**RE: Request for Further Information
Lingard Private Hospital Expansion (SSD-60316710)**

This letter is submitted to the Department of Department of Planning, Housing and Infrastructure in response to the Request for Further Information (RFI) issued on 10 December 2024, relating to SSD-60316710 for the proposed expansion of the Lingard Private Hospital.

DRAWING TITLE: PROPOSED SHADOW DIAGRAMS JUNE - SHEET 01
SCALE: As Shown

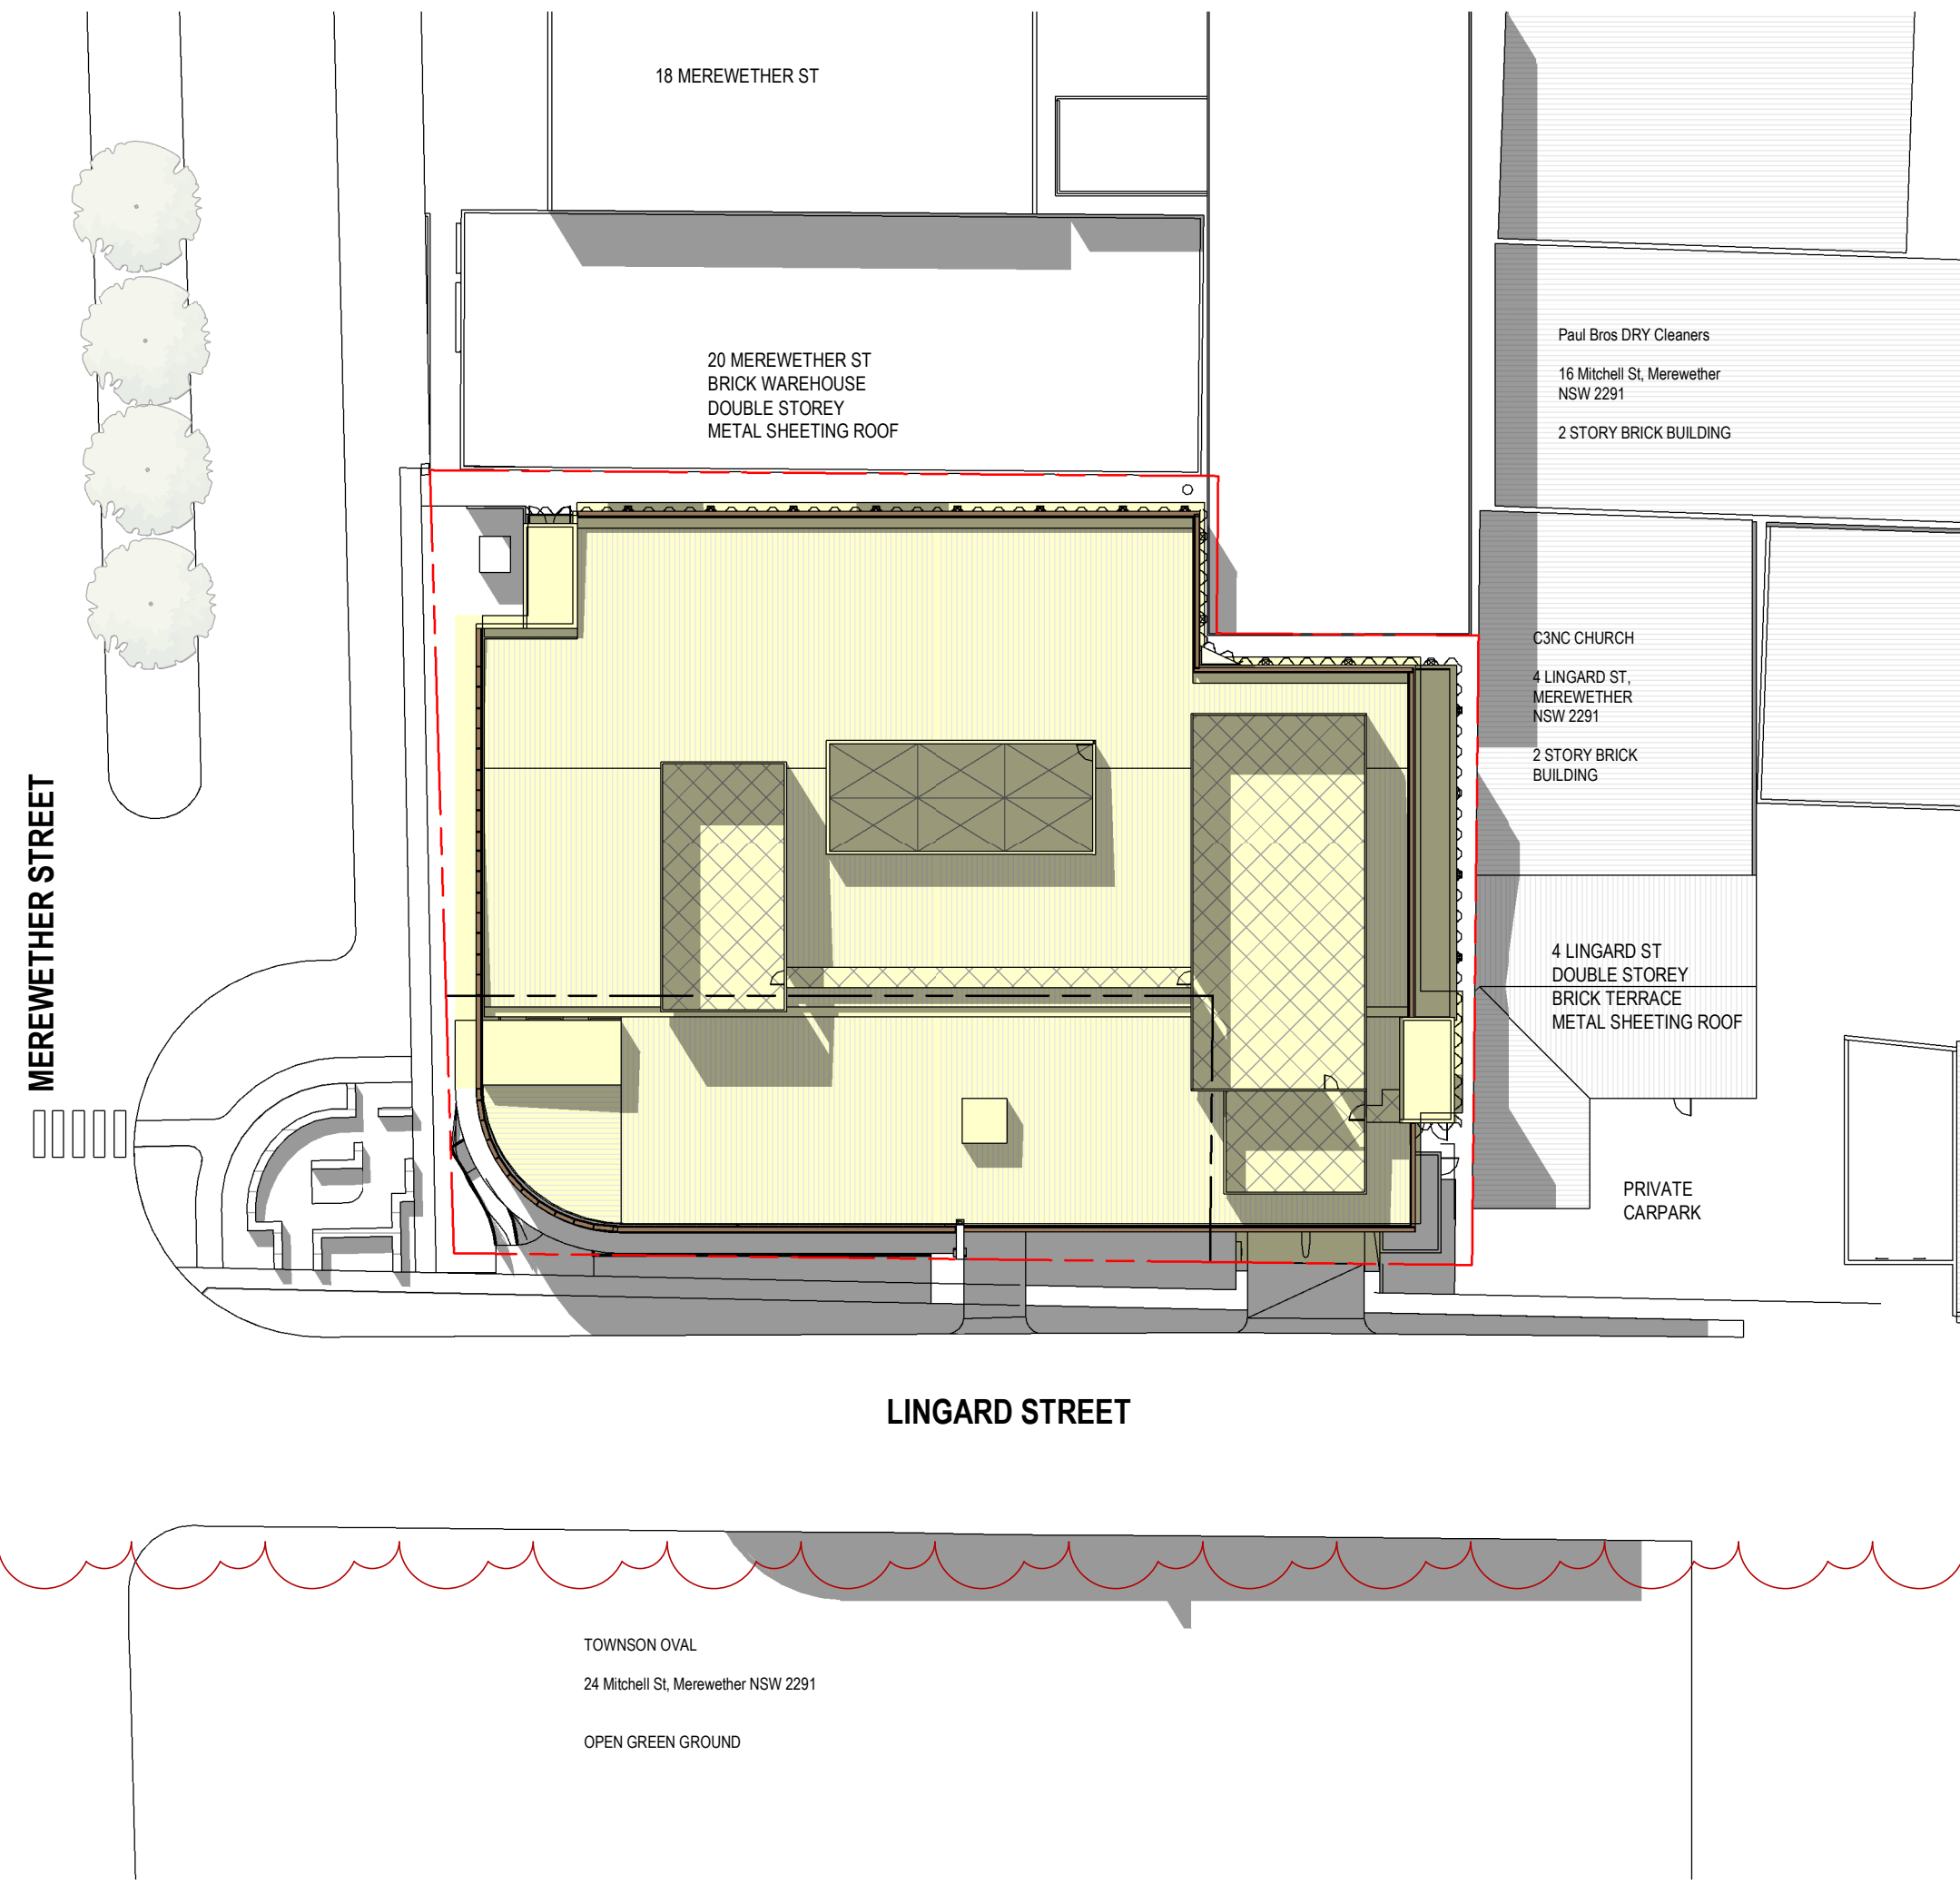
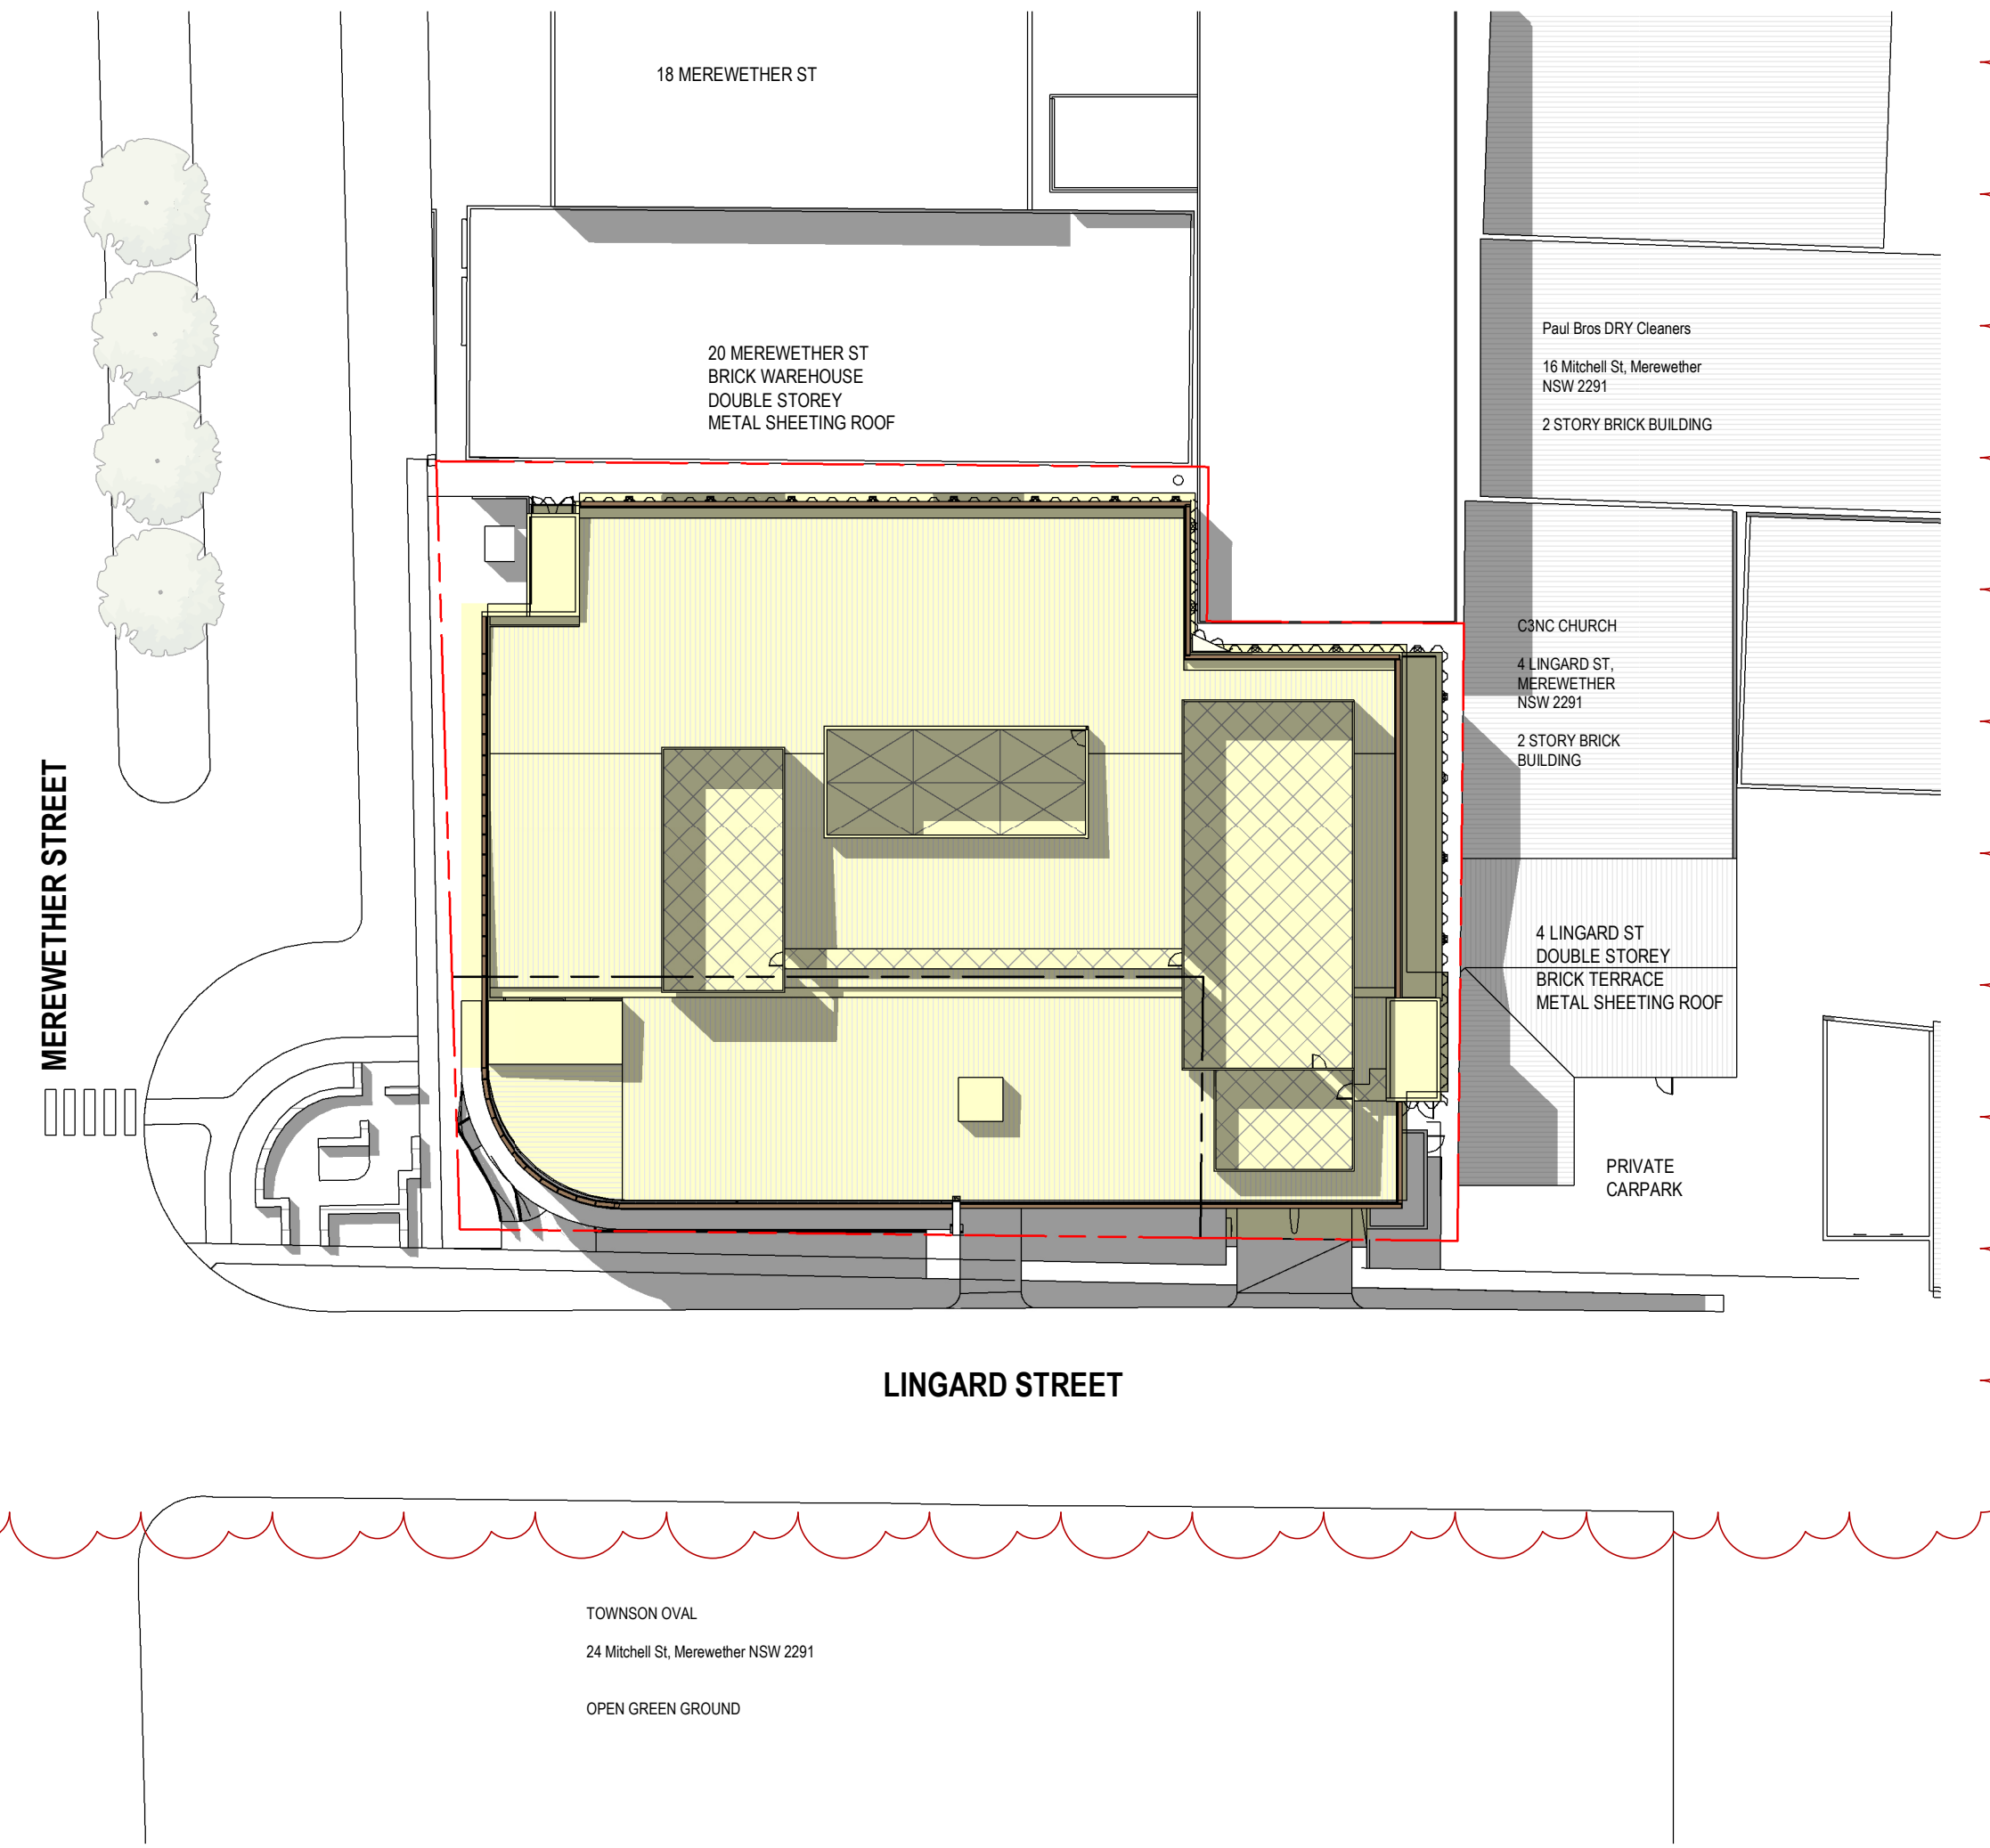
CN's concerns regarding residential amenity remain. The amended architectural plans do not include hourly shadow diagrams or 3D shadow analysis to identify the habitable rooms and private open space of residential properties, as previously requested. The shadow impact to Mitchell Park has not been adequately addressed.

The non-compliant height coupled with reduced setbacks on the eastern boundary of the Hopkins Precinct, exacerbate the amenity impacts. CN recommends the design is amended to reduce the bulk and ensure upper floor levels comply with the setback requirements and maximum building height development standard. CN recommends the applicant is required to submit additional shadow diagrams at hour intervals between 9am and 3pm during the June 21 winter solstice.

Additional shadow diagrams have been provided at Appendix A. The overshadowing of Mitchell Park is minimal, occurring only at 9 AM during winter. The affected area consists of large trees and on-street parking that would naturally be in shadow. The proposal ensures ample daylight reaches the trees and surrounding area at all other times.

The amended shadow diagrams include percentage calculations for the surrounding residential dwellings and confirm compliance. The most significant impact is on 11 Merewether Street in the afternoon; however, the existing shadow diagrams show that this is also the present state, refer to Figure 1 & 2 below. In the previous iteration of plans the second level wall was also setback further from this boundary.

Overall, the proposed height variation does not result in any unreasonable adverse impacts on neighbouring properties in terms of bulk, scale, overshadowing, or privacy. The minor exceedance is justified by the functional necessity of the affected building elements and their limited contribution to the overall form, ensuring a well-balanced outcome that meets the intent of the planning controls while supporting high-quality urban design. Additional shadow diagrams are provided at Appendix A.
